Your Ref: OWPC21263
Our Ref: BR/215/18/PL 27-07-2018
Please ask for:
Mr S Davis

Conversion & extension of dwelling comprising two existing flats to form 6 No. flats (4 No. new) with associated ancillary services.

75 Highfield Road Bognor Regis

Thank you for your internet representation made on 28th January 2019 which has been recorded as '**an objection**' with the comments as follows:

Parking Sweep Diagram 1:200

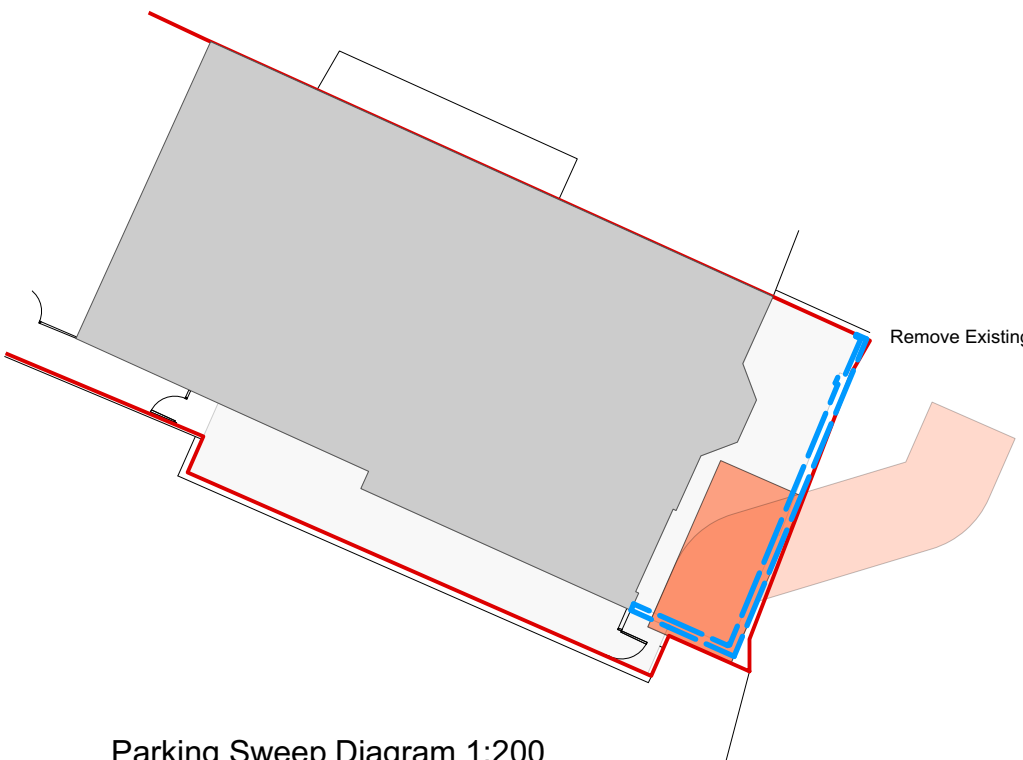
As I stated in my previous comment I object to this planning application due to the lack of parking. Its good to see that some of the issues have been addressed in the new plan, however 1 parking space is not adequate parking for 6 flats in an already full road of parked cars. I also have concerns on the logistics of the build in regards to lorries and work vehicles, I have a young family and real consideration and care needs to be taken. As you can see from all the previous comments the road can get congested as it is used as a cut through, there have already been stand offs and accidents. I was also unaware that a new plan had even been submitted until informed by another neighbour a few days ago. With regards to the council surely a new notice should have been provided to give the neighbours an opportunity to comment in time on the new plans. I feel this is very unfair on the residents of Highfield Road.
